Reserved Matters Application including access, layout, landscaping and scale pursuant to Outline Planning Permission 14/02121/OUT for internal Primary and Secondary Streets along with the part discharge of conditions 12, 16, 17 and 19 for Phase 1B at Himley Village, Bicester

Further to discussions with yourself and Officers at Oxfordshire County Council Highways Department I am submitting a revised scheme pursuant to Reserved Matters application 23/01493/REM for Phase 1B, Himley Village, Bicester.

TITLE  
**S278 OFFSITE HIGHWAY WORKS  
 PRIMARY ACCESS JUNCTION  
 GENERAL ARRANGEMENT  
 SHEET 1**

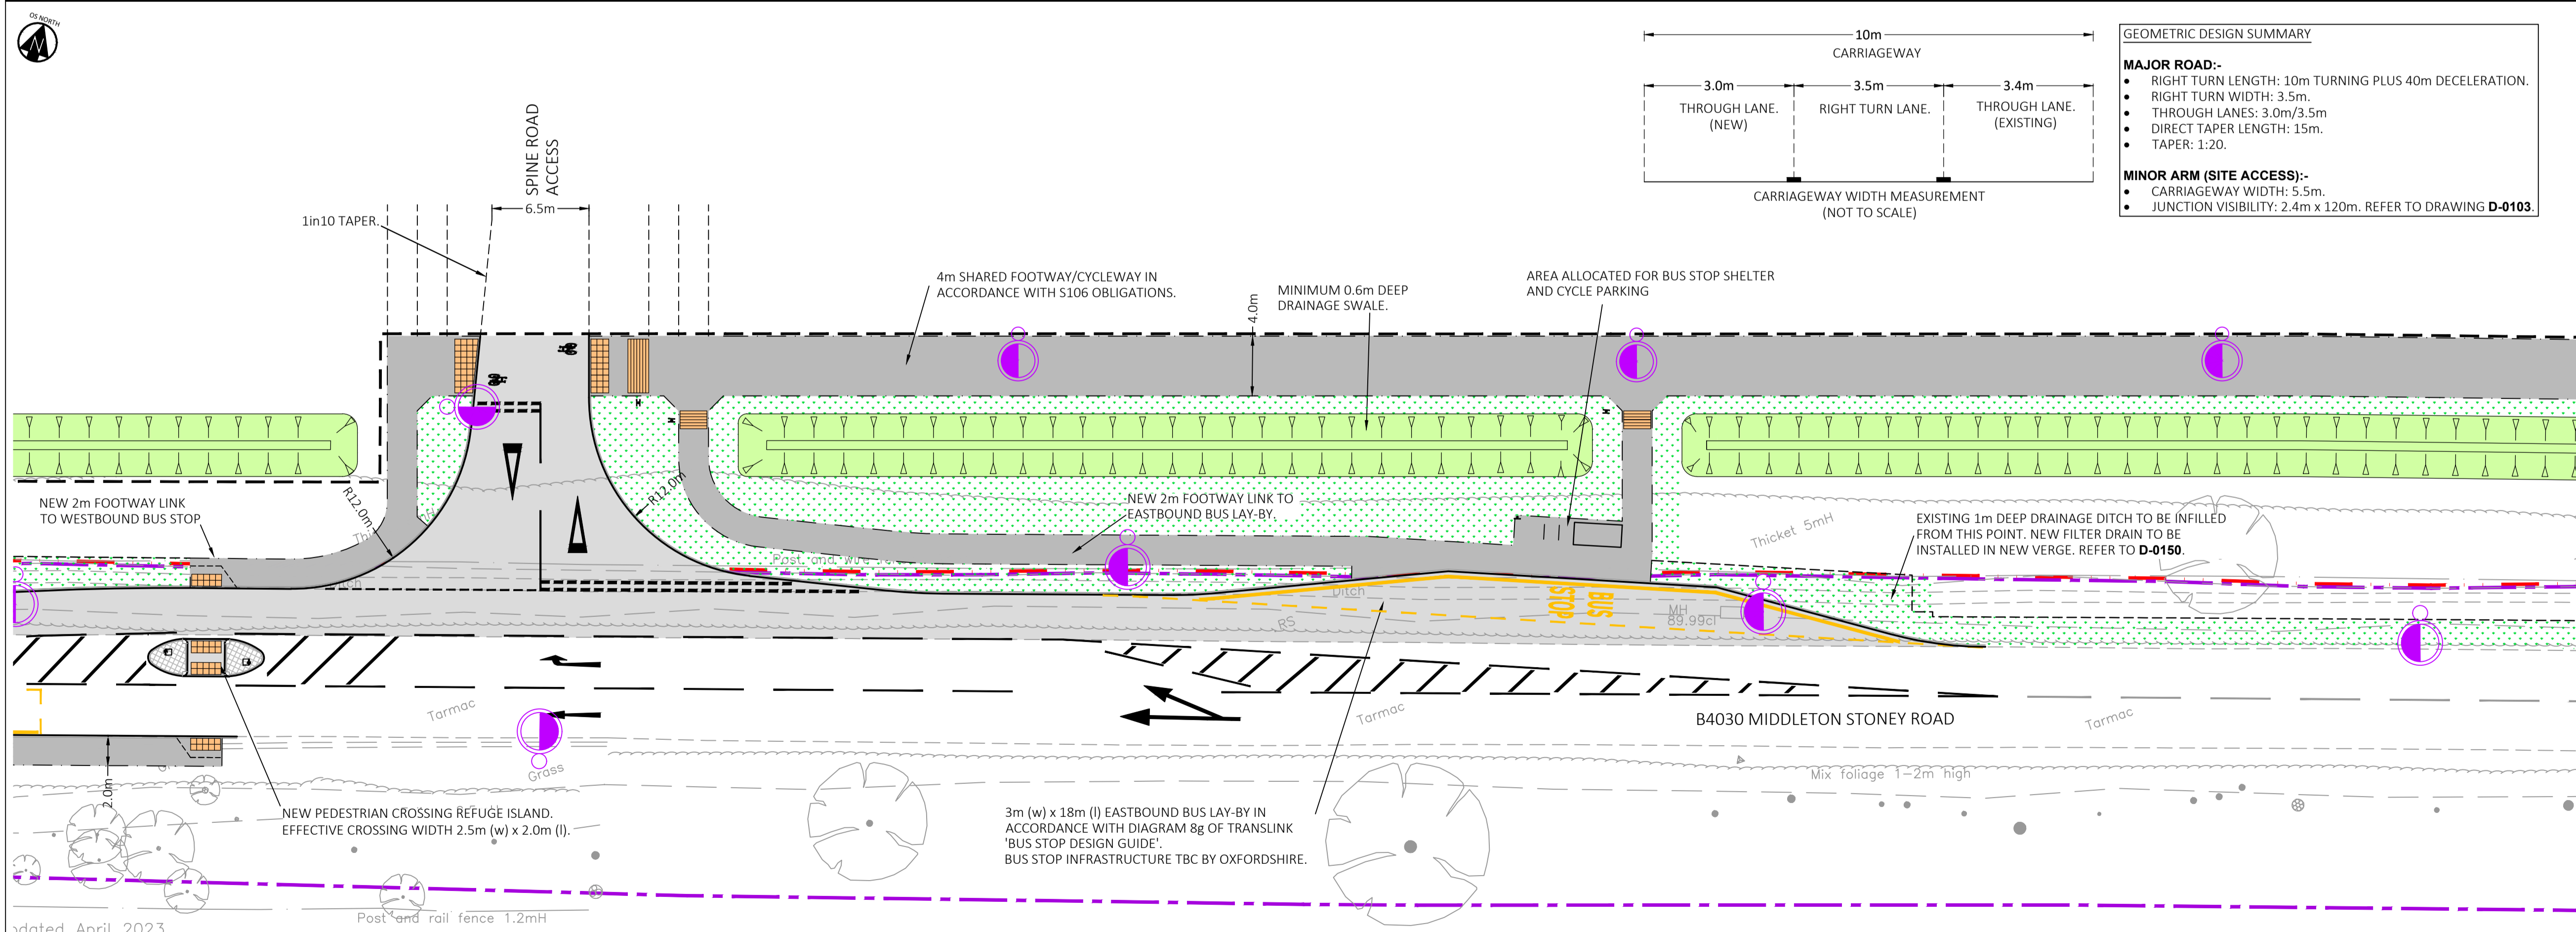
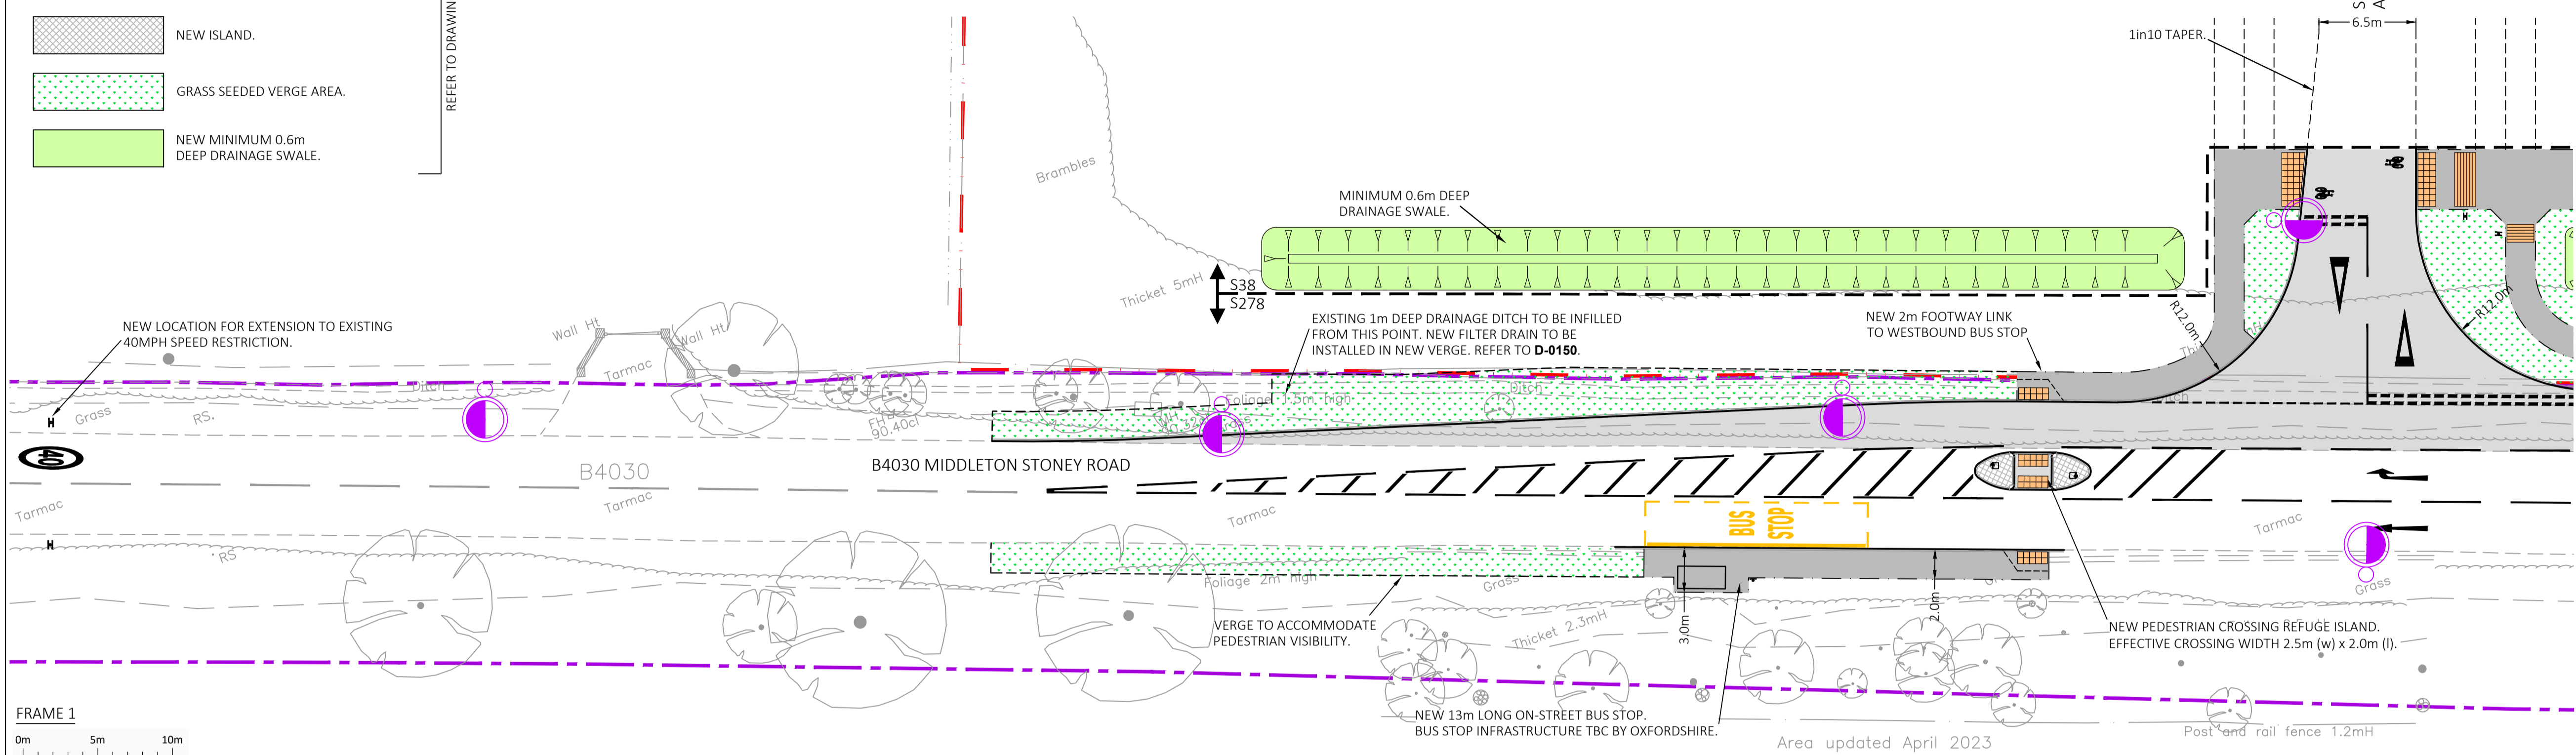
- The 6.5 metre wide Primary Access (western) is designed to accommodate future two bus flows. The Secondary Access (eastern) will not be subject to two way bus flows, so the width of 5.5 metres will be sufficient. The respective road widths accord with the consented layouts and geometry detailed in the Section 106 Agreement. The Oxfordshire County Council Highway comments also state that if the Strategic Secondary Access is not used as a bus route, then a carriageway width of 5.5 metres is acceptable.
- Where the cycle track cuts through the hedge in the south east corner of the Phase 1B red line, the horizontal alignment has been amended to provide a 'lazy S' bend to ensure a smooth transition between the on site 4 metre wide footway / cycleway and the off site 3 metre wide footway / cycleway. At the point of transition, additional width has been provided within the

TITLE  
**S278 OFFSITE HIGHWAY WORKS  
PEDESTRIAN/CYCLE LINK  
GENERAL ARRANGEMENT  
SHEET 3**

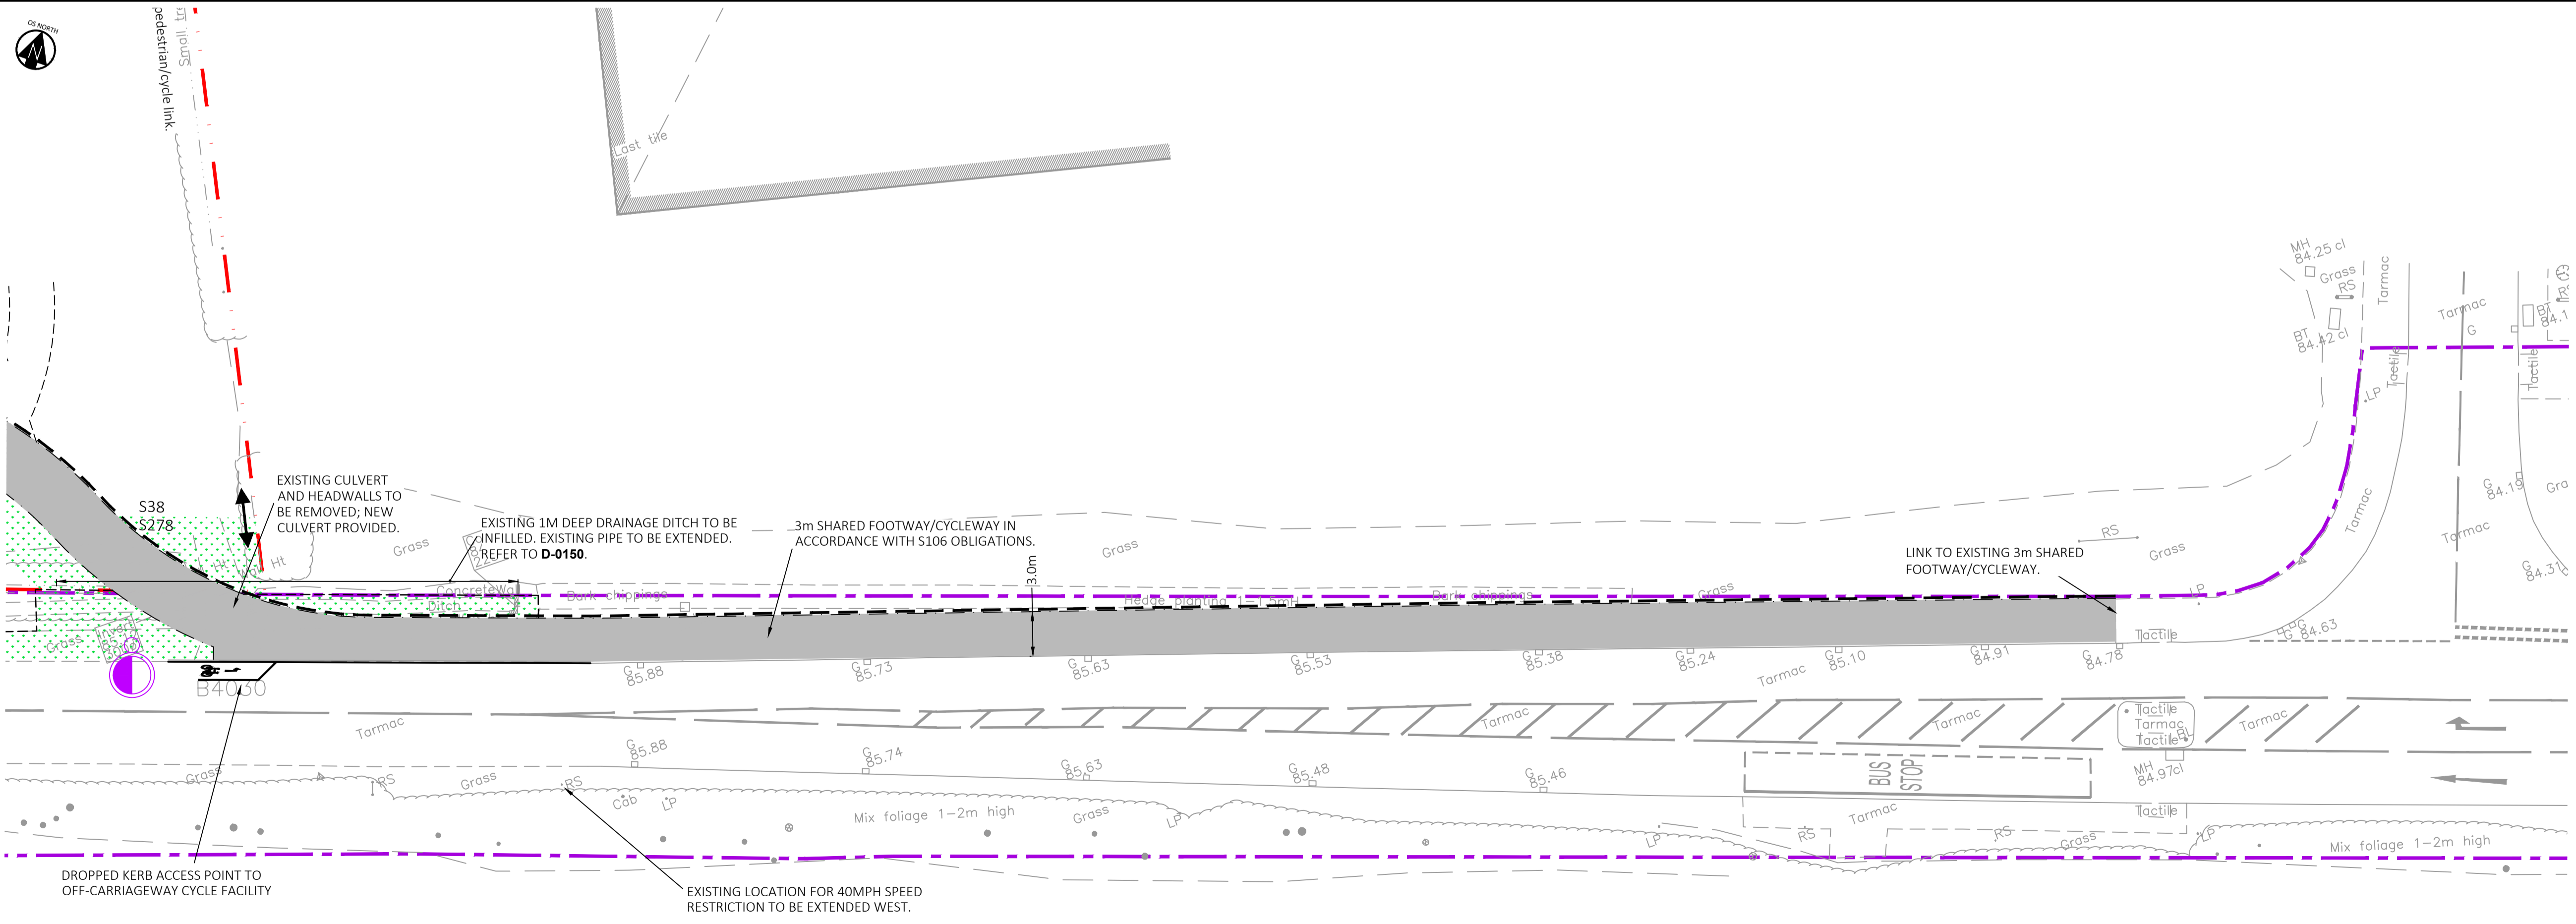
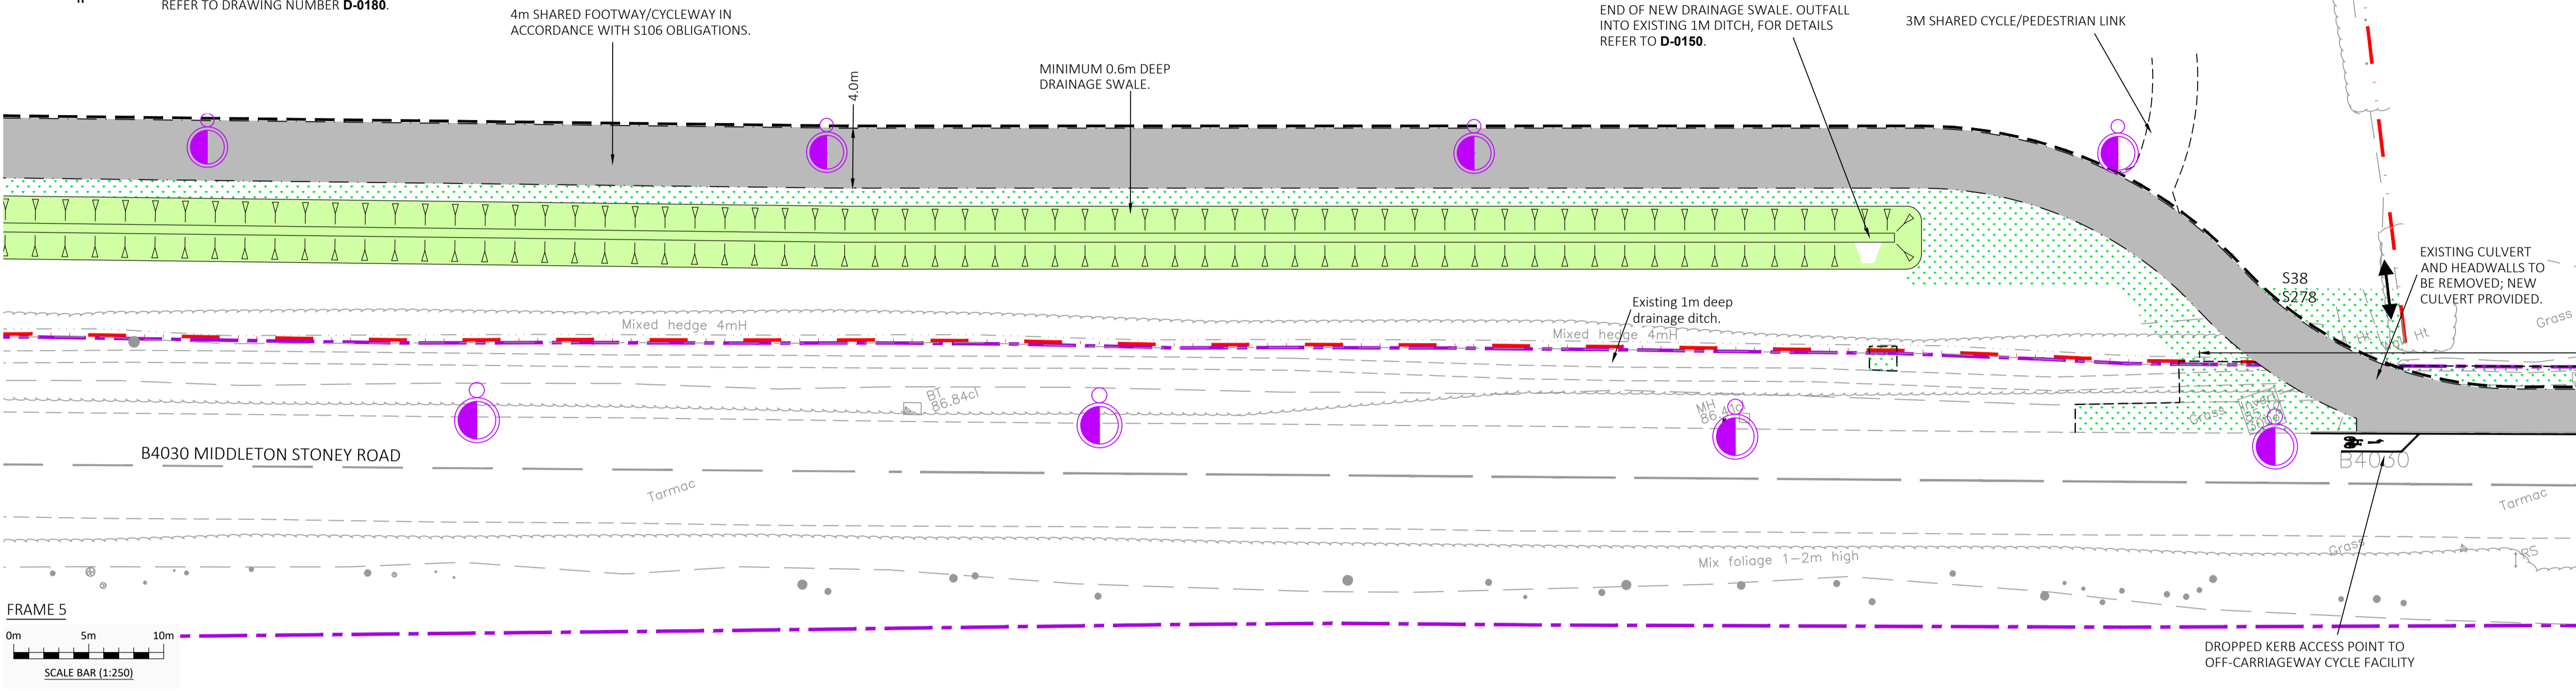
- The proposed footway / cycleway along the 'on site' southern boundary has been updated to be 4 metres wide. The extent of the public highway along Middleton Stoney Road, to the east of the development is circa 3 metres from the edge of the carriageway. Therefore, to deliver infrastructure within the limit of the land within Cala Homes' control, a 3 metre wide footway / cycleway is proposed to be constructed from the south eastern corner of the site and to connect into the existing 3 metre wide footway / cycleway near to Stirling Road.
